# Consultee Comment for planning application 6/2019/1788/COND

<b>Application Number</b>	<input type="text" value="6/2019/1788/COND"/>
<b>Location</b>	<input type="text" value="Former Shredded Wheat Site Broadwater Road Welwyn Garden City AL8 6UN"/>
<b>Proposal</b>	<input type="text" value="Submission of details pursuant to condition 5(Surface water Discharge) 6 (Drainage System) 52 (Provision of open space/play space)35 (Delivery of accessible Housing) 13 (Highways) 37 (Vehicle access Point to Pall Mall Site) 50 (Refuse Storage Arrangements)on planning permission 6/2018/0171/MAJ"/>
<b>Case Officer</b>	<input type="text" value="Ms A Christophi"/>
<b>Organisation</b>	<input type="text" value="WHBC - Client Services"/>
<b>Name</b>	<input type="text" value="Lorraine Davis"/>
<b>Address</b>	<input type="text" value="Client Services The Campus Welwyn Garden City AL8 6AE"/>
<b>Type of Comment</b>	<input type="text" value="ConditionalResponse"/>
<b>Type</b>	<input type="text"/>

PROJECT TITLE FORMER SHREDDED WHEAT FACTORY			
DRAWING TITLE PHASE ONE REFUSE COLLECTION BLOCK 11			
CLIENT / ARCHITECT METROPOLITAN			
STATUS			
SCALE 1:250	AT A3		DRAWN LL
CHECKED RF			APPROVED
DRG SIZE A3	DATE 10/19	DRAWING NUMBER SK202	REV B

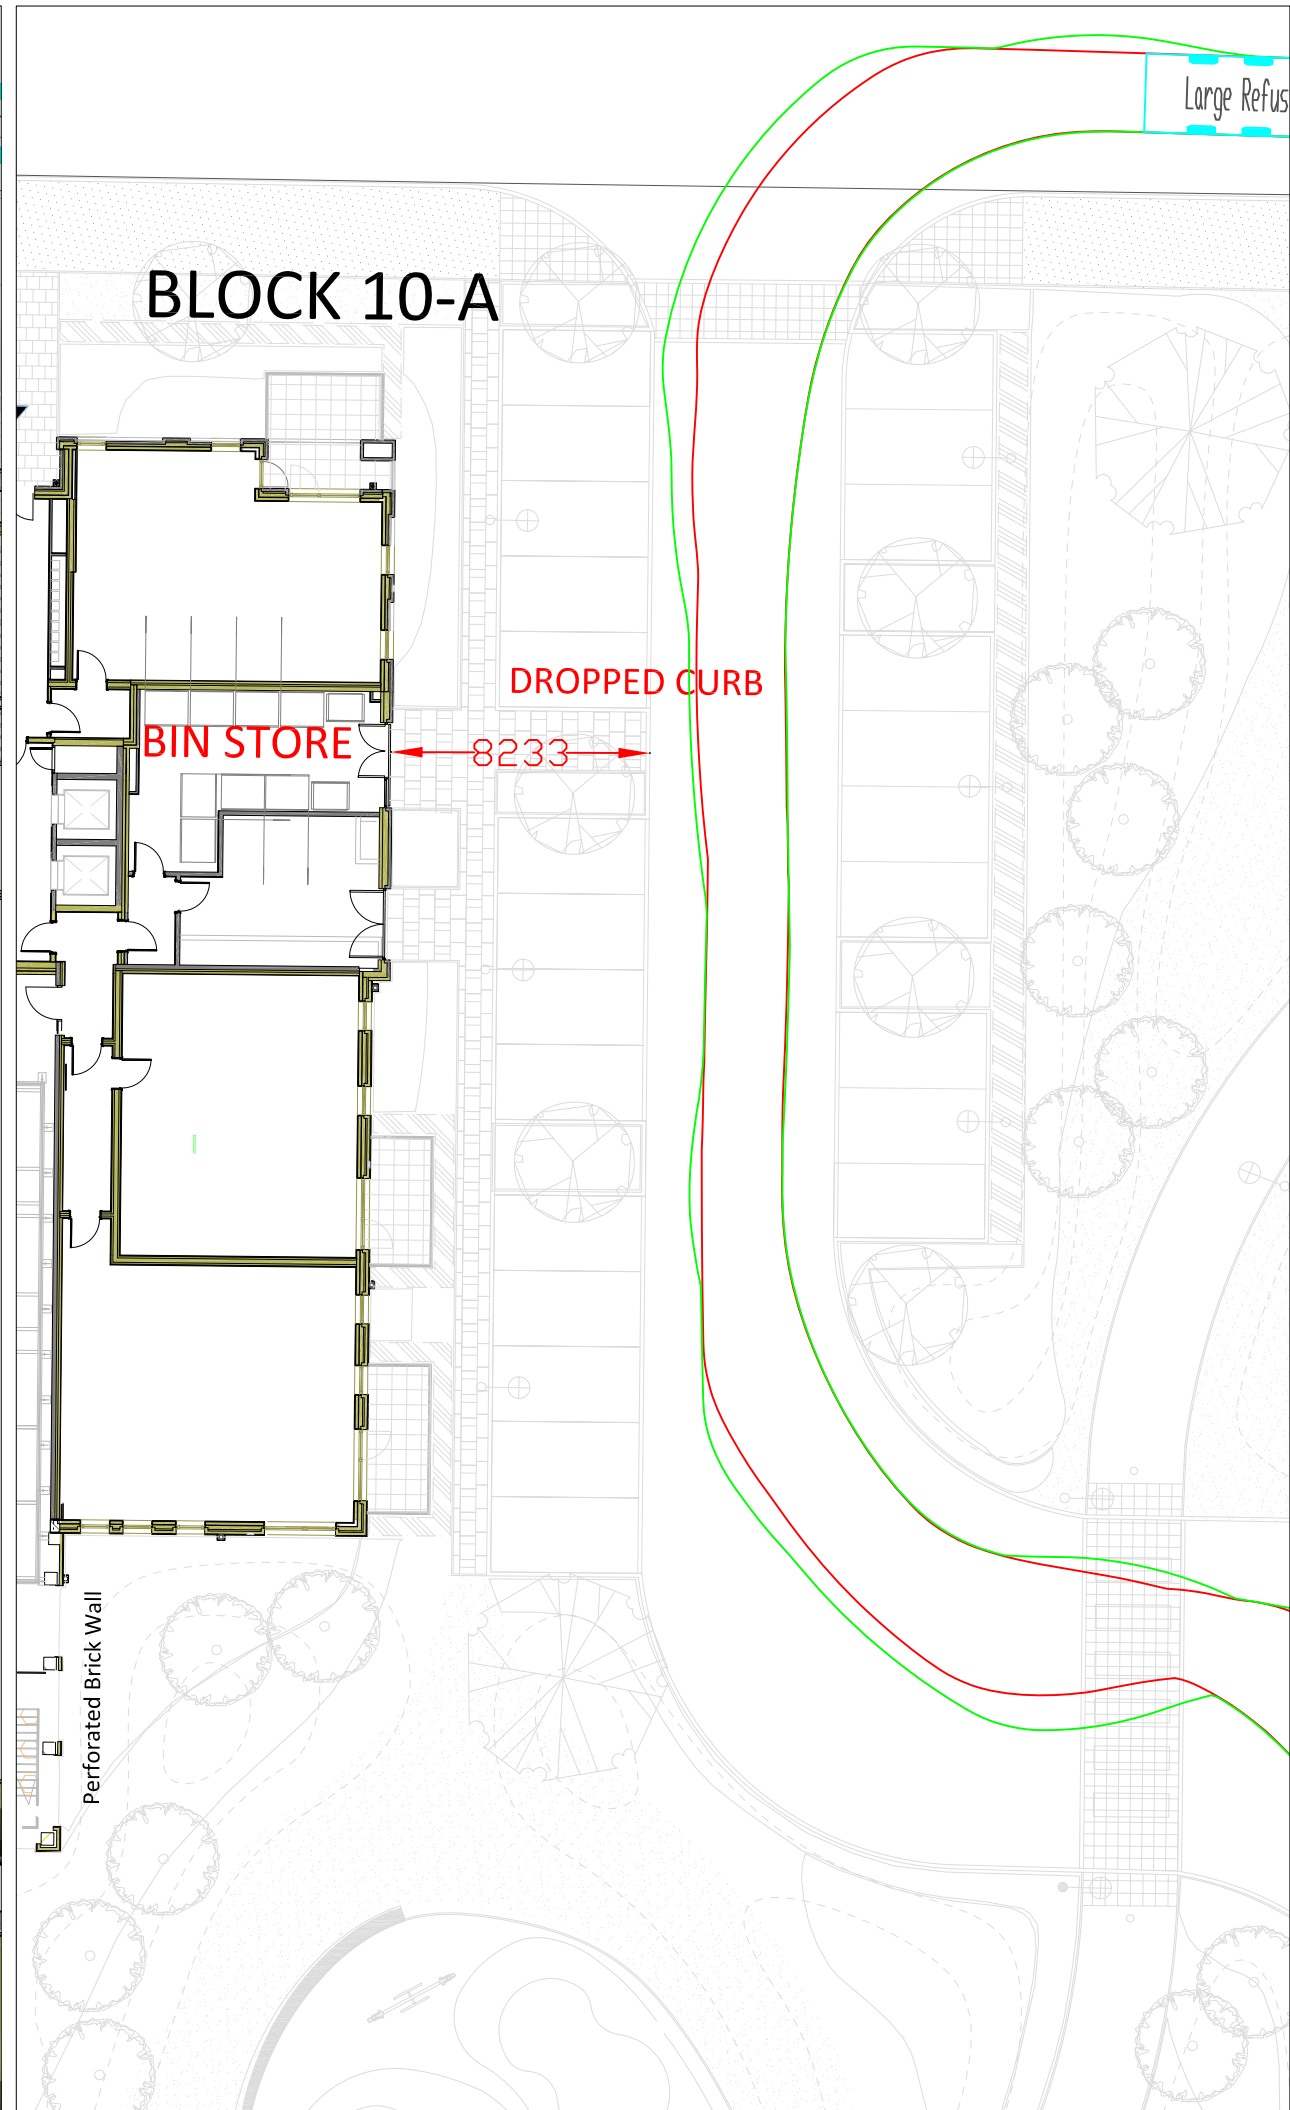
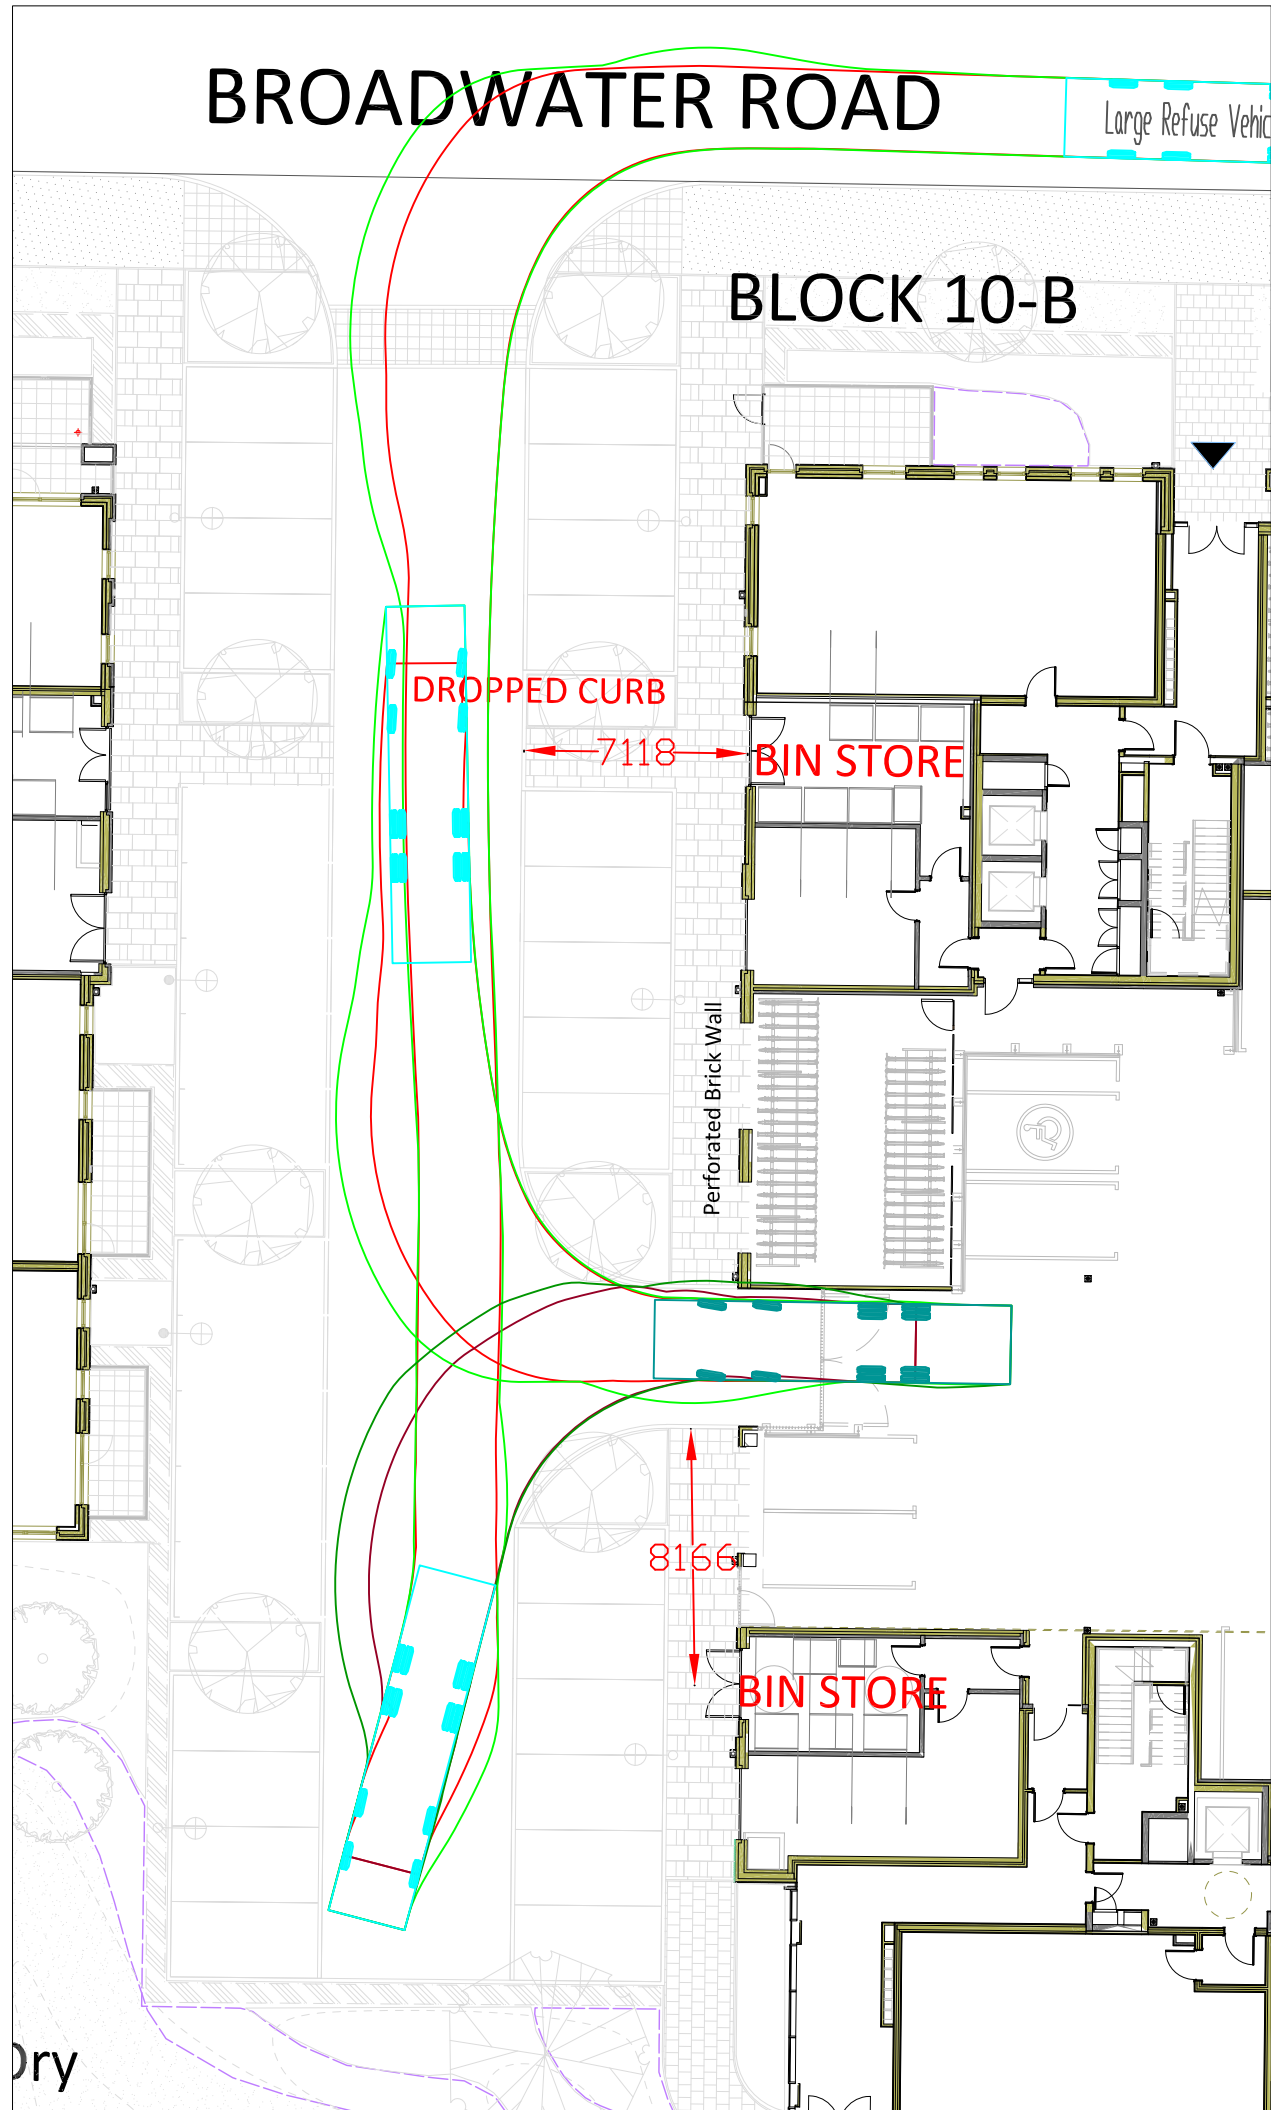
<b>Comments</b>	<input type="text" value="29/07/2019 - Lorraine Davis The number of refuse 1100l containers allocated to each of the Bin stores for Block 10 &amp; 11 is acceptable, however, there is no provision for the MRC's (Mini REcycling Centres) the dimensions of these being on the attached Bin Store Guidance document. Block 10A and 11A will require 2 MRC's each and 10B/C and 11B/C will require 1 each. The cost of the MRC's is ?560.00 each and 1100l containers ?390.00 each. Can you please supply diagram with drag distances from bin store to freighter annotated on . These are to be no more than 15m, however, our preference is 10m. Also please confirm that there will be dropped kerbs and minimum 2m wide smooth paths from store to freighter with no steep gradients as noted on the original application. We would also like confirmation that there will be dedicated bays/keep clear markings for collection vehicles to be able to access the areas as the majority of accesses are within the parking bay areas for the flats."/>
